HINCKLEY RAIL FREIGHT TERMINAL

Comments on Written Responses

Sapcote Parish Council

Oct 2023

Drawing Title
GENERAL ARRANGEMENT SHEET 18

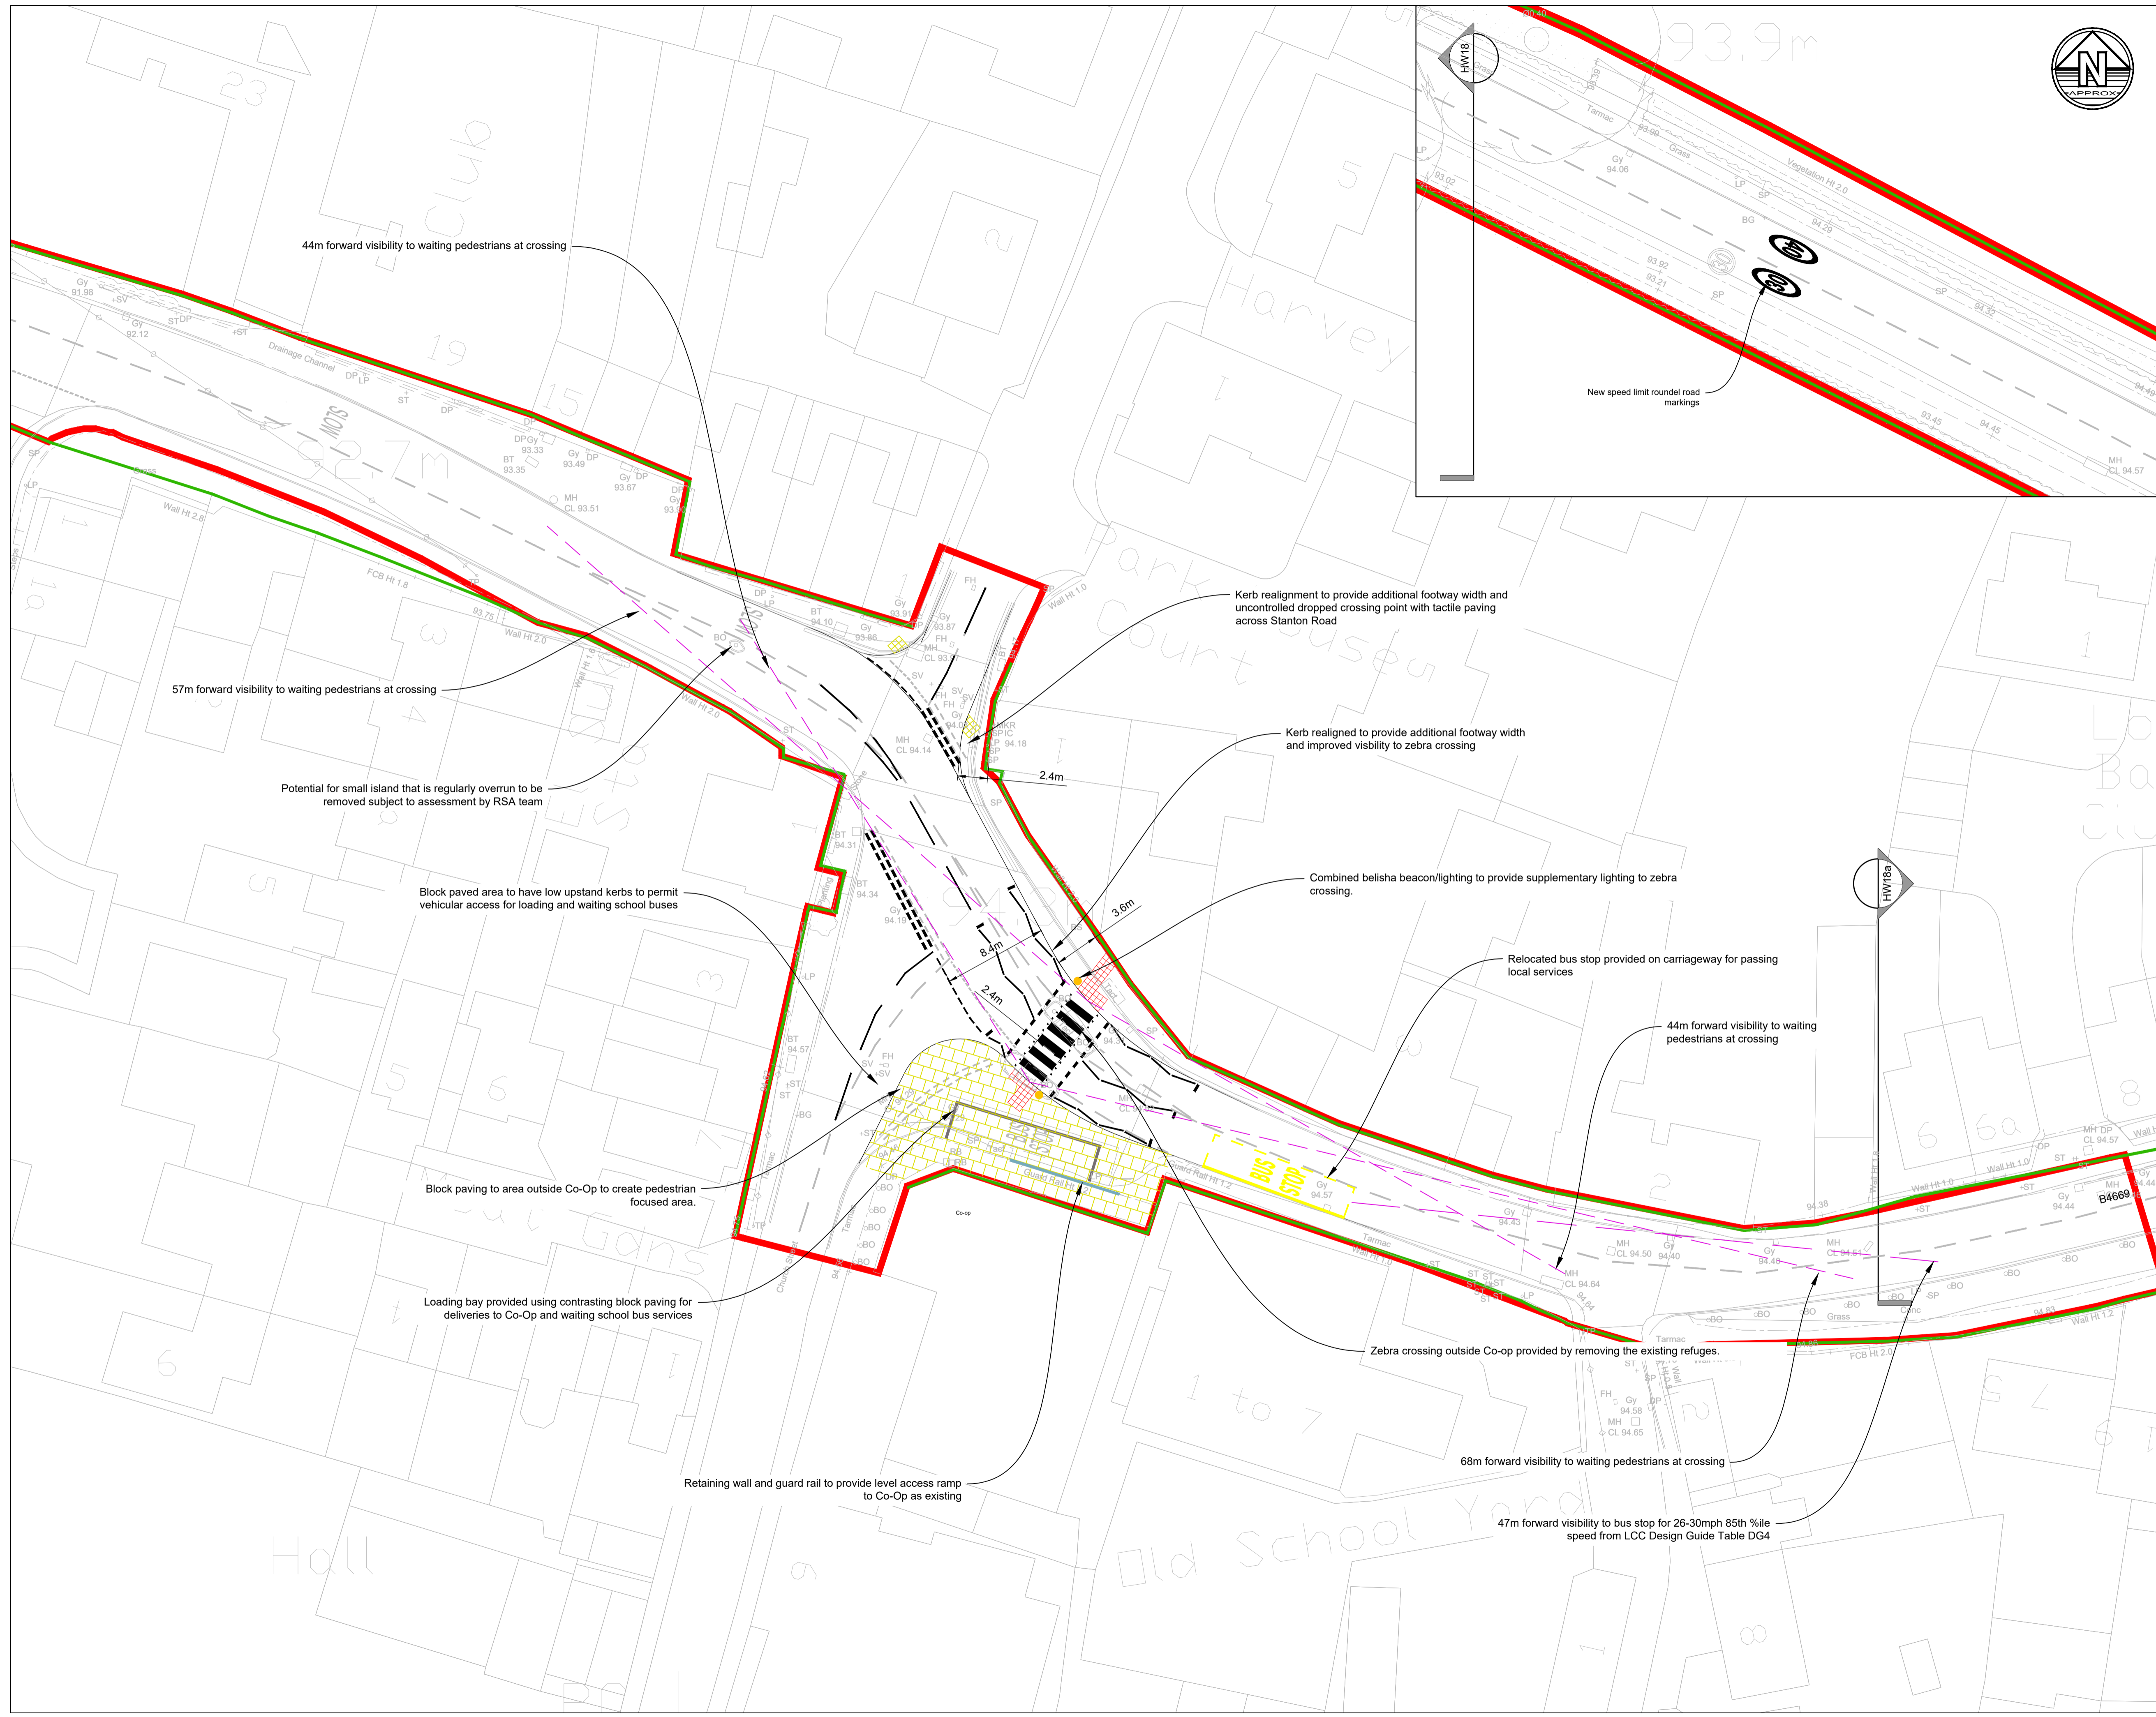
1.11 Para 2.95 refers to a proposed zebra crossing in Sapcote. We were completely unaware of this. Unfortunately, neither we nor anyone in Sapcote has been approached regarding these proposals as far as we can tell.

However, based on local knowledge this is proposed to be in a part of the village with restricted forward visibility from the east, heavy footfall, and in a location where available carriageway and footway widths are restricted.

1.14 It can be seen that the zebra crossing would be provided next to the section with the most limited road width (as set out in our previous comments) and where there are significant visibility issues. It is also where children currently cross the road (with a traffic warden). Given the increase in traffic on this section of road, including HGVs, introducing a zebra crossing which relies on driver behaviour to be safe at such a sensitive location may not, in our mind, be beneficial.

1.15 Moreover, the proposals require the removal of the off-road bus stop outside the Co-Op and its relocation north beyond the narrow section of road and pavement where it may delay traffic.

1.16 This was previously used by the X55 but that was replaced by the Fox Connect who use that layby for pick-ups and drops-off as well as the other bus stops in the village. Under the new regime anyone using that service and wishing to access the centre of the village would have to negotiate the narrowest section when alighting from a bus.

1.17 In addition, all secondary aged children have to travel to local towns for schools. The majority travel by bus to either Broughton Astley/Lutterworth or Burbage/Hinckley. Buses collect children in the morning and drop them off at the end of the day from that bus stop, as this is currently a safe place to access a bus in the centre of the village.
